From: Nicola Swann <[REDACTED]>
Sent: 31 July 2019 13:22
To: Planning.Responses <Planning.Responses@arun.gov.uk>
Subject: Pagham responses

- 1.2 **P/58/19/PL – Rear of Inglenook Hotel, 253-255 Pagham Road, Pagham PO21 3QB. Erection of 9 No dwellings with associated access, parking, cycle & refuse storage & landscape design. This application is a departure from the Development Plan and may affect the setting of a listed building. RESOLVED: OBJECT.**
The Parish Council wished to object to the application on the following grounds:

Front Elevation (Units 7)

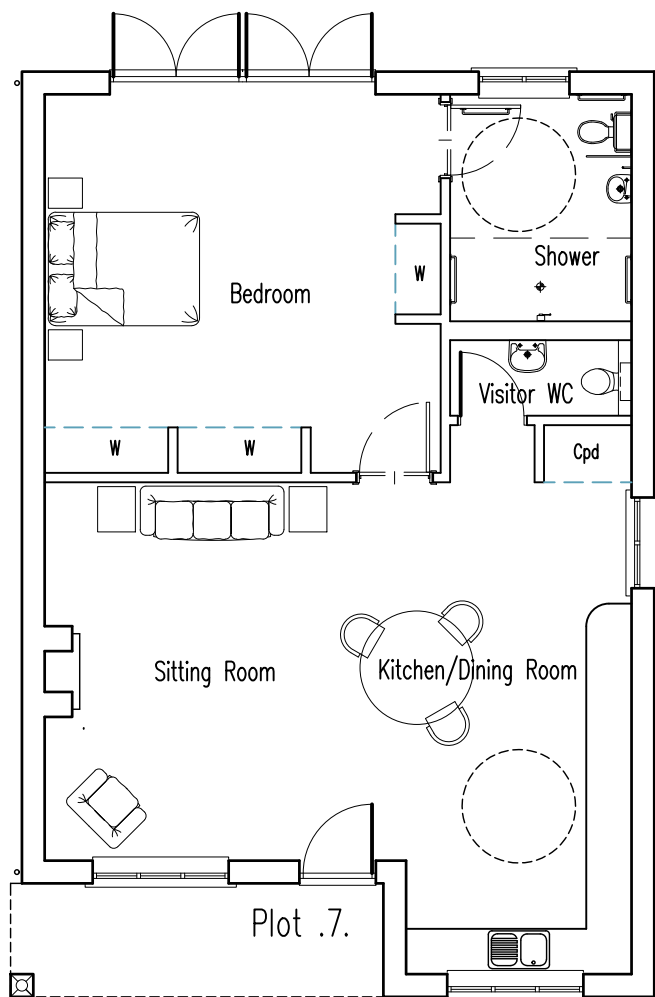
1. The impact on the neighbouring properties at Mill Farm Estate was unacceptable. The development was considered to be unneighbourly and contrary to Policy D DM1 of the Arun Local Plan 2018 para 3 - Have minimal impact to users and occupiers of nearby property and land. For example, by avoiding significant loss of sunlight, privacy and outlook and unacceptable noise and disturbance. This was particularly evident from the scale of Unit 7 and the proximity to the neighbouring Mill Farm Estate properties.
